From: Zac Denton
Sent: 03 April 2019 11:18
To: Karen Parsons
Subject: FW: 'Fidra' Yapton Road. Ref. M/9/19/HH

The proposal is a two storey rear extension, that extends 6m from the rear wall of the original host dwelling, and 9.5m from the ridge (at maximum height). I will be raising concerns with my Team Leader about this application in our next case review.

DWG. No. 1901191/PL/1A

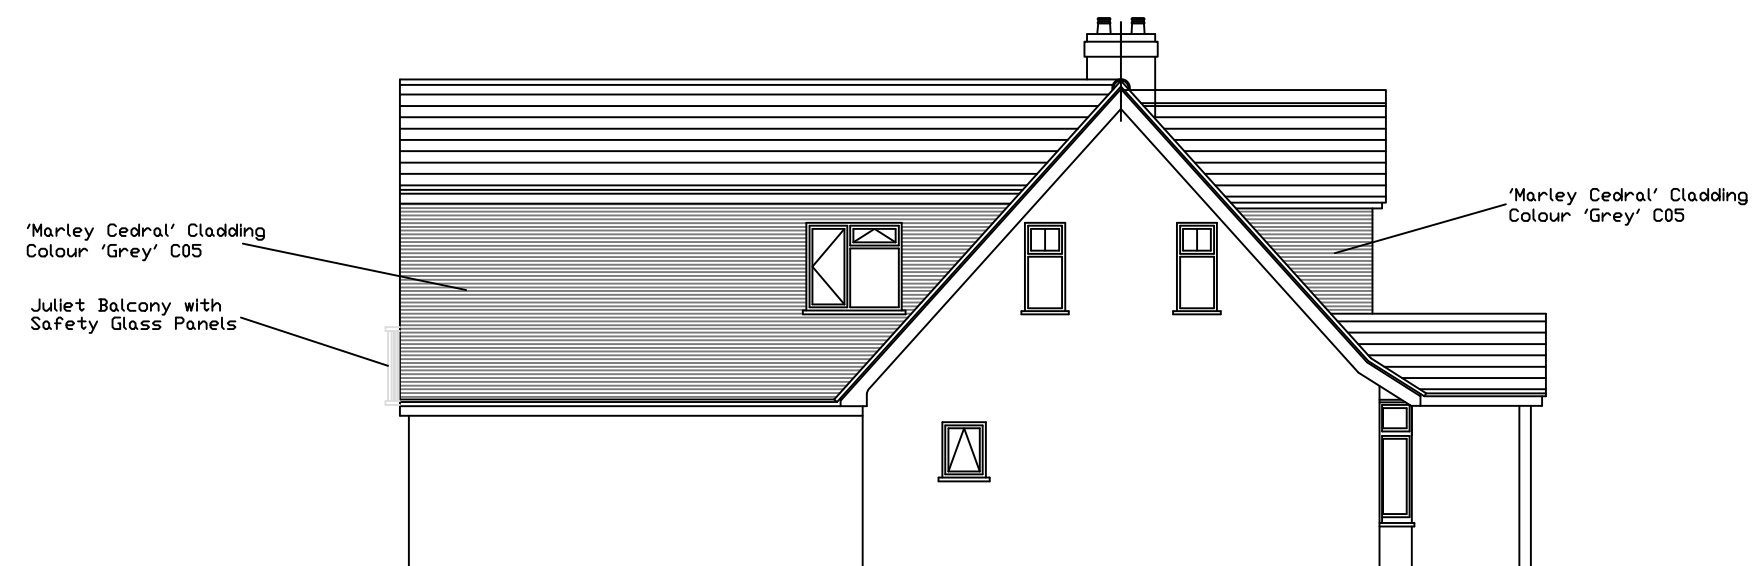
I hope you are well. I have spoken to my Team Leader regarding this application. The main concerns relate to the bulk of the proposal. These could be addressed by a hip being introduced on the rear, the lowering of the pitch height and reduction of the overall projection. I am open for negotiation on this application if you have thoughts/proposals!

Yes, I'm good thanks. Hope you are too after the shock weather yesterday. Yes. agree with the Extension of time and the ideas. The only one I need confirmation on is the Projection. Do you want to reduce the length by a Mtr. or is the length ok.
